Commitment Letter

Project Name: McGehee Subdivision

Description: McGehee Subdivision is proposed with two (2) residential lots on approximately 10.50 acres. The development is the replating of Lot 3 of Mountain Shadow Ranch Second Phase. This proposed subdivision is located east of Highway 83 and north of Hodgen Road in Section 19, Township 11 South, Range 65 West.

FINAL PLAT

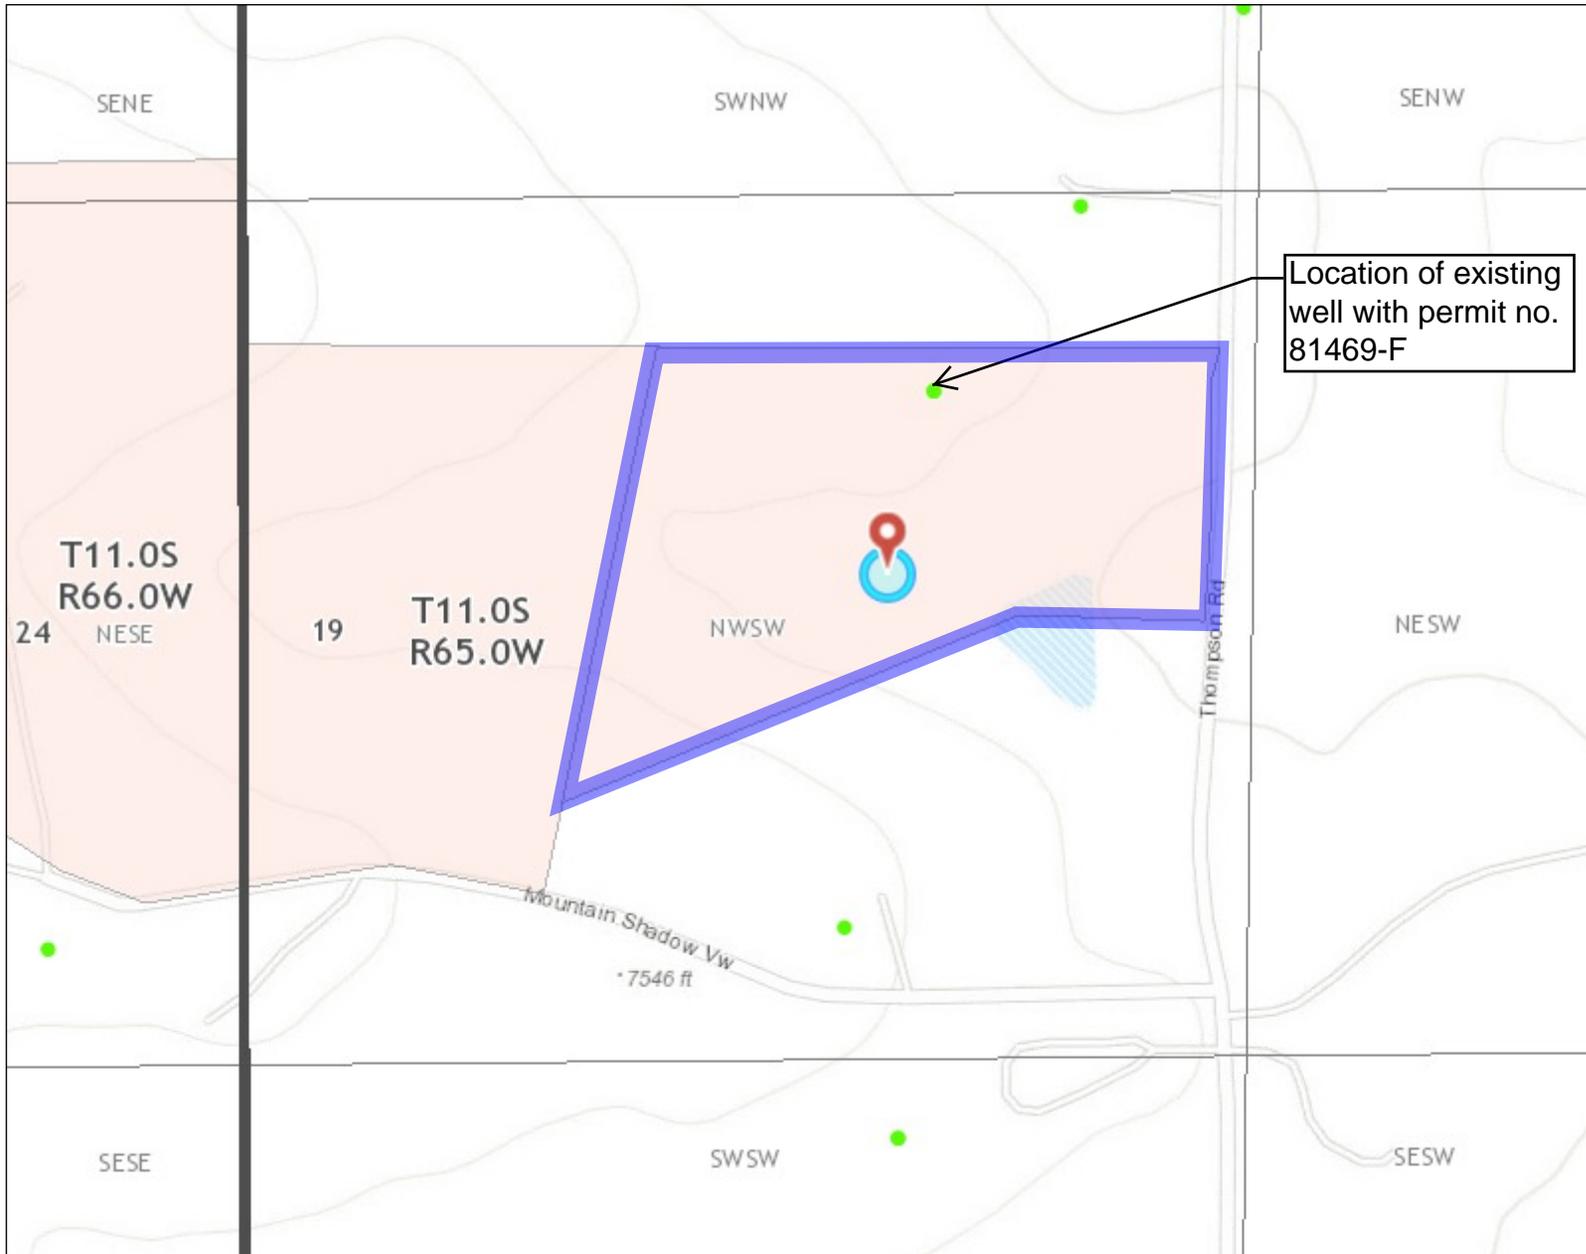
Show on plat

MVEA requests a five (5) foot both sides of the common side lot line utility easement along with a twenty (20) foot exterior utility easement on plat. MVEA also requests platting of existing MVEA facilities with easement on the plat. If open space, road right of ways, drainage and landscape tracts are designed in this subdivision MVEA requests these areas be listed to include utilities. Additional easements may be required once a review of civil drawings with grading and erosion plan is provided to MVEA.
